Heckington Fen Solar Park

Cover Letter

Application by Ecotricity (Heck Fen Solar) Limited for development consent for the Heckington Fen Solar Park

**Response to the Planning Inspectorate's section 55 advice dated 13 March 2023
Ecotricity (Heck Fen) Solar Limited ("the Applicant")**

DATE	SCALE	SHEET	REVISION
24/01/2023	1:2,500@A1	7	.

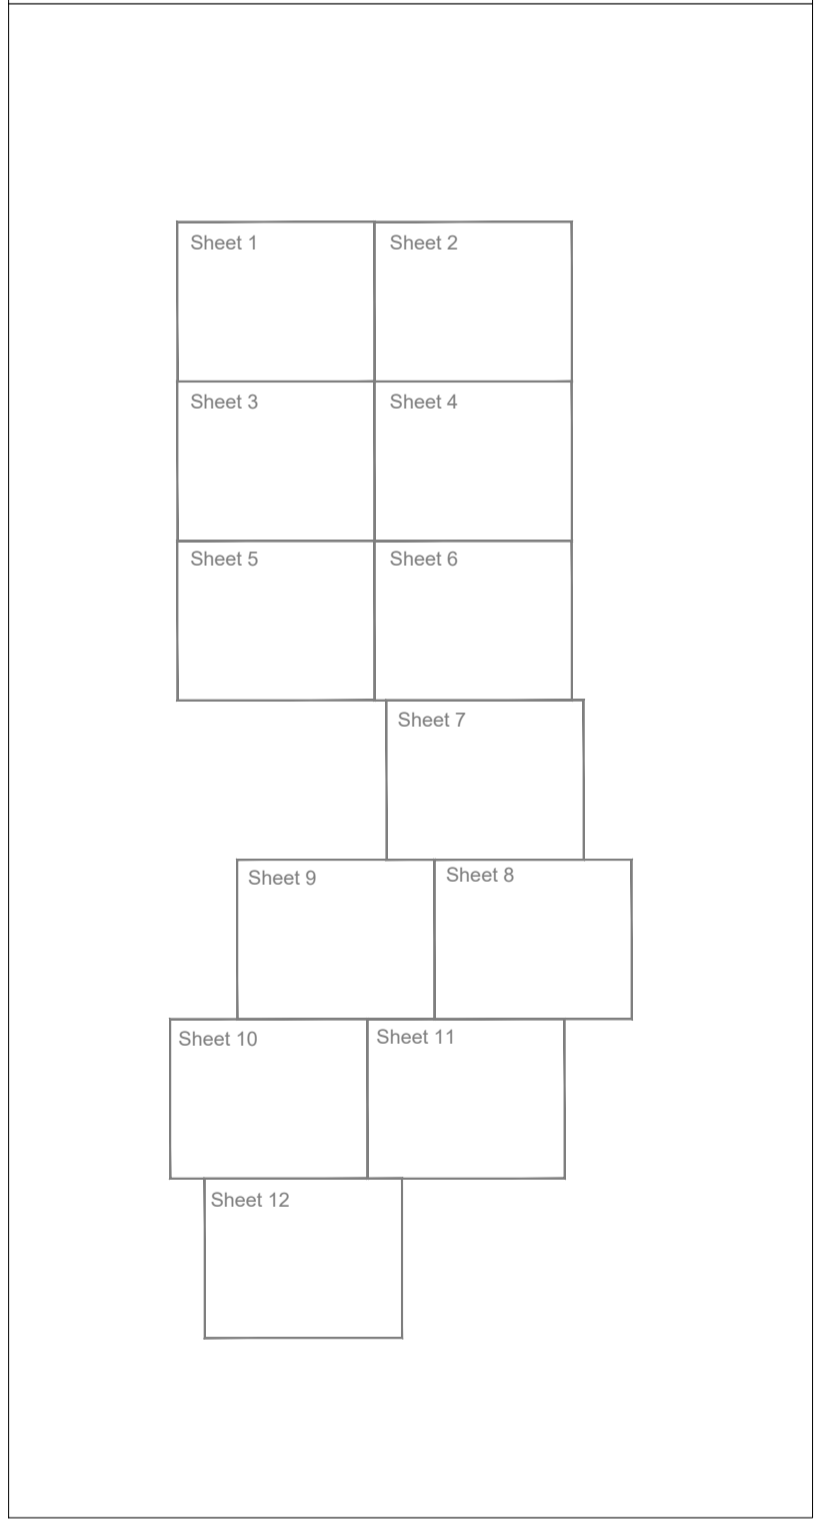
Box 30 - Point 4	Street and Access Plan (Doc 2.7)	
	In Schedule 4 of the draft DCO 'Royalty Lane' is named, but this is missing from Sheet 7.	A label for Royalty Lane has been added to Sheet 7. The Streets and Access Plans have been reissued as Document Reference 2.7 – V2.

<p>On sheet 7 identifiers CR/B and CR/D appear to be slightly off from where they need to be located.</p>	<p>Identifiers CR/B and CR/D have been relocated slightly to align with position of junctions on the A17.</p> <p>The Streets and Access Plans have been reissued as Document Reference 2.7 – V2.</p>
<p>Box 30 - Point 5</p>	<p>Draft Development Consent Order (Doc 3.1)</p>	
	<p>Schedule 13 Parts 1 to 8 of the draft DCO provide draft protective provisions with a number of undertakers and organisations. Notwithstanding this, there are other potential interests such as Triton Knoll and Viking Link with whom protective provisions may be required. Therefore, the Applicant is advised to check that all the relevant draft protective provisions have been provided and, if not, then early engagement with any other parties is advised.</p>	<p>Schedule 13 Part 1 of the draft DCO (document reference 3.1) provides general protection for electricity, gas, water and sewerage undertakers. Therefore, in the event that a statutory undertaker does not have bespoke protective provisions within Schedule 13 they will, nevertheless, be covered by the general protective provisions at Part 1 of Schedule 13.</p> <p>The Applicant is engaging with Triton Knoll and Viking Link to discuss protective provisions. To the extent that these statutory undertakers require bespoke protective provisions, the bespoke protective provisions will be included as a new Part within Schedule 13 of the DCO.</p> <p>This position is explained within paragraph 8.1.23 – 8.1.24 of the Explanatory Memorandum (Document Reference 3.3).</p>

DATE	SCALE	SHEET	REVISION
24/01/2023	1:2,500@A1	9	.

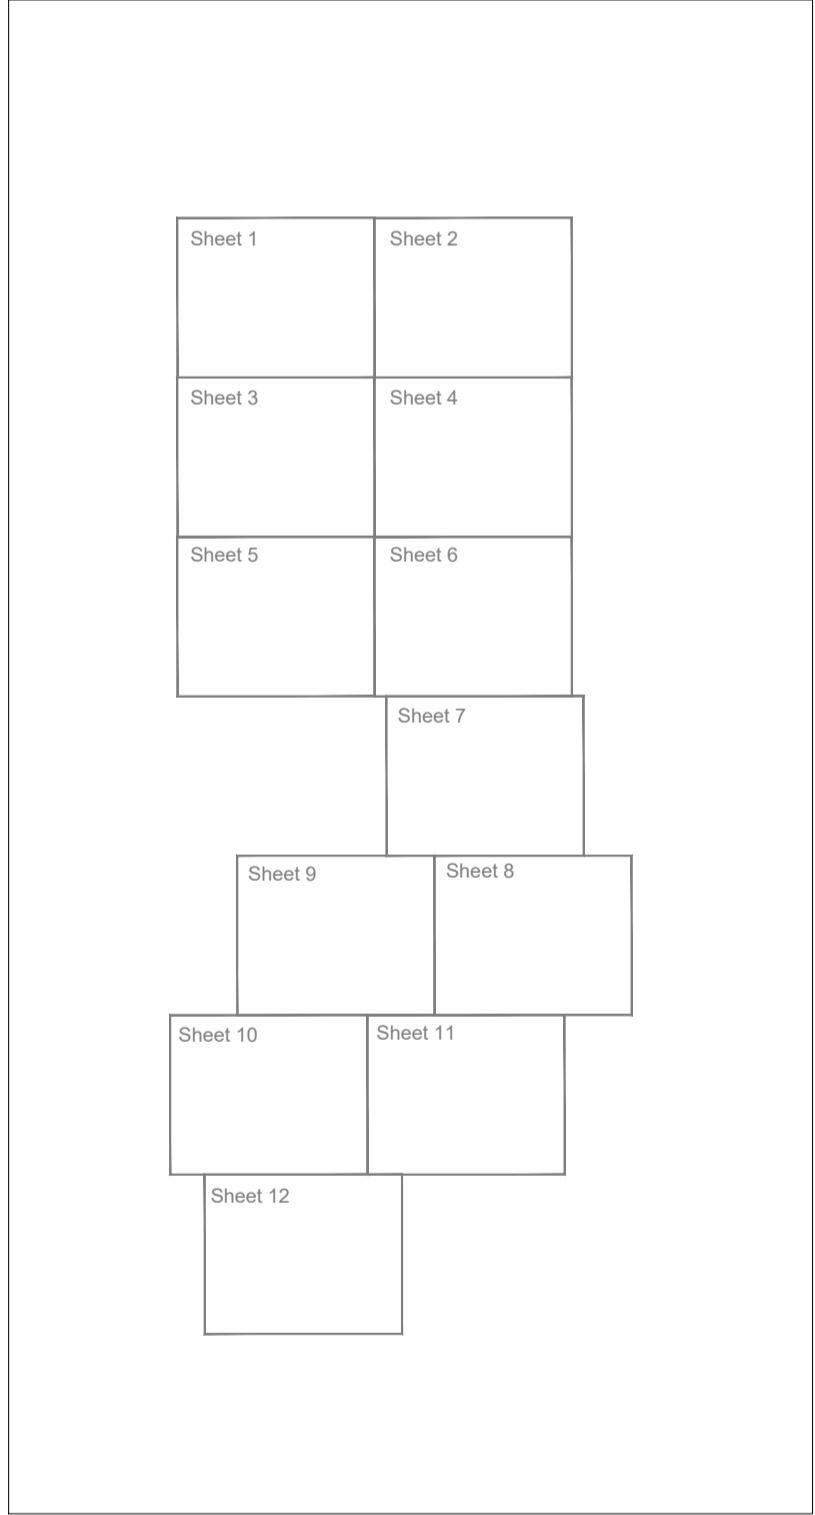
<p>In Schedule 4 of the draft DCO 'Timms Drove' is named, but this is missing from Sheet 9.</p>	<p>The label for Timms Drove was previously obscured by the Order Limit boundary, this been added to Sheet 9.</p> <p>The Streets and Access Plans have been reissued as Document Reference 2.7 – V2.</p>
	<p>On the maps and legend 'Temporary means of access to works' is coloured purple however schedule 7 of the draft DCO describes this as being coloured blue. The applicant should update this inconsistency to provide clarity.</p>	<p>The Applicant has updated the text in the draft Development Consent Order to refer to the area "coloured purple" rather than "blue". The Applicant has provided an example from Schedule 7 of the draft DCO below: :</p> <p><i>"The provision of a temporary means of access to the authorised development from the north side of the A17, at point EP/A and the area coloured purple on sheet 5 of the Streets and Access Plan."</i></p> <p>A revised draft Development Consent Order is included as Document Reference 3.1 – V2.</p>
